Application by Highways England for an Order Granting Development Consent for the A38 Derby Junctions Scheme
The Examining Authority's first written questions and requests for information
Issued on Friday 11 October 2019.

The following table sets out the Examining Authority's written questions and requests for information to assist with the assessment of the application.

Drawing Number Highways England Pin Originator Volume HE514503 -ACM -EGN-	Rev C01
A38_SW_PR_ZZ -DR-LE-0020	
Location Type Role Number

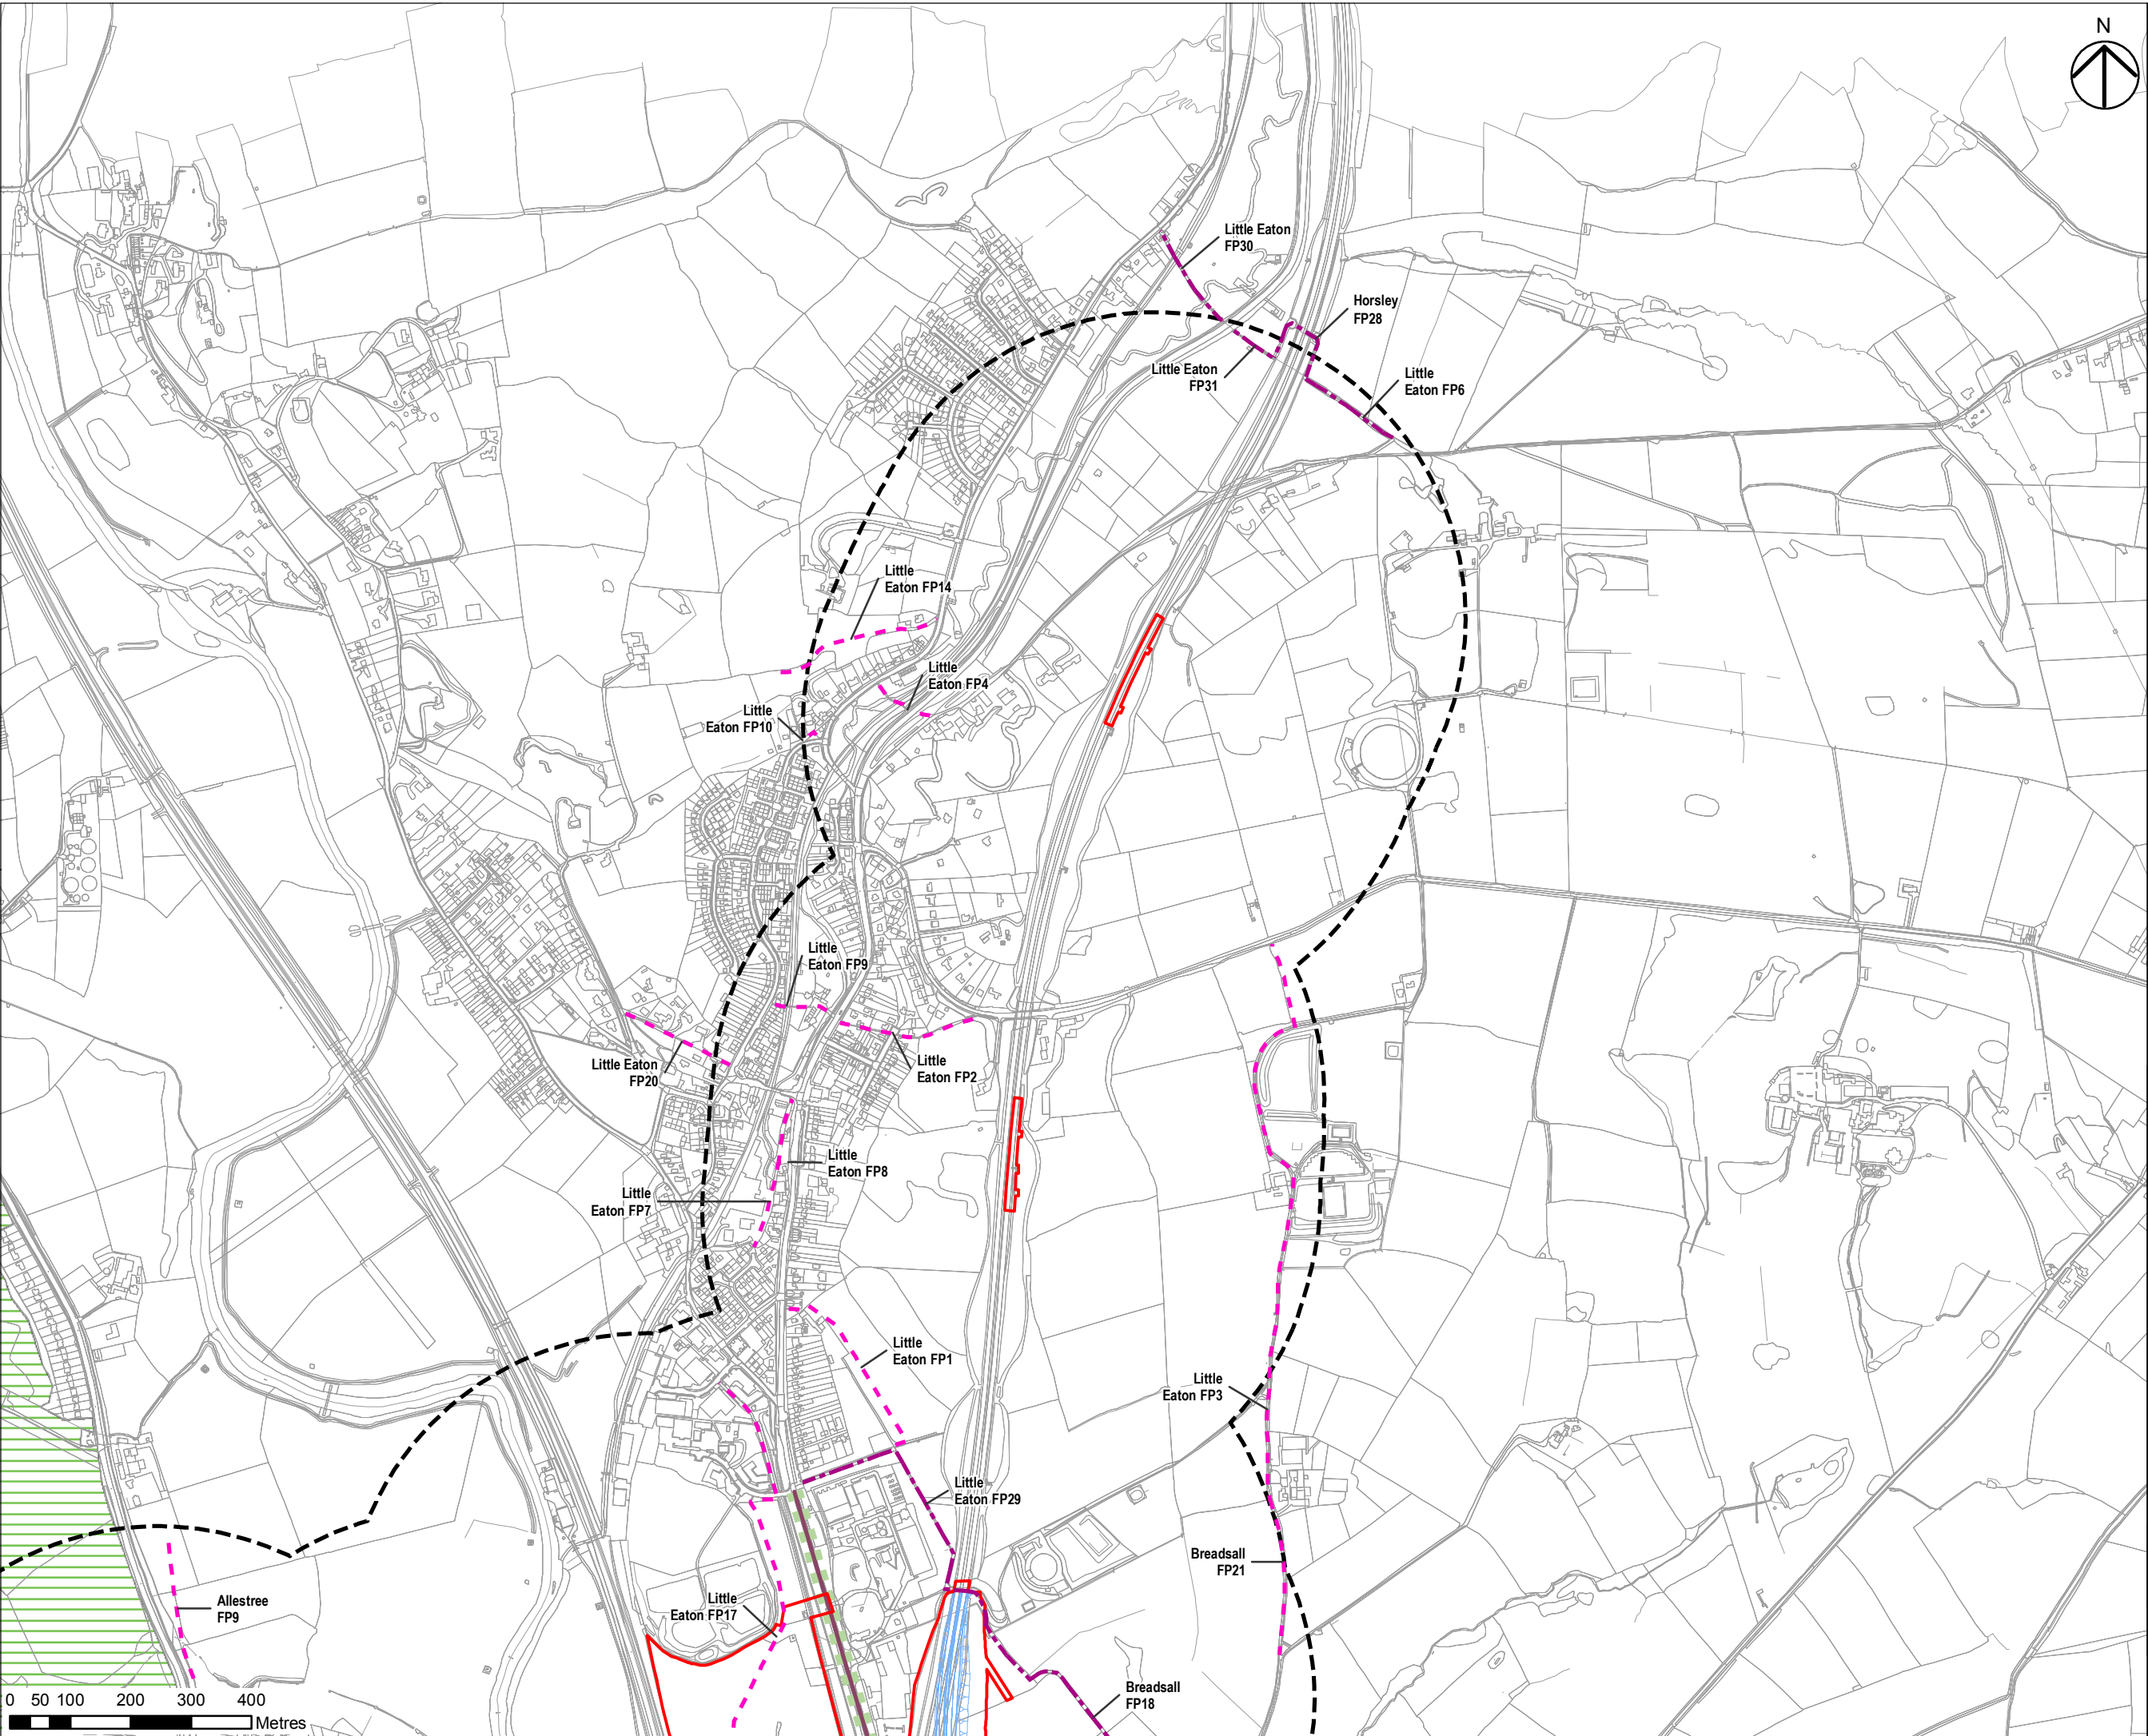
No	Question to	Reference	Question
4.4.	DCiC DCC EBC	Study areas and road sections ES Chapter 12 – People and Communities [APP-050] paragraph 12.6.3 and Table 12.14 ES Figures 12.1A-D [APP-142, 143, 144 and 145]	a) Are the Local Authorities content with the study area used in relation to transport networks and traffic, including for the assessment of driver stress? b) Are the road sections identified in ES Table 12.14 appropriate and representative for the driver stress assessment?
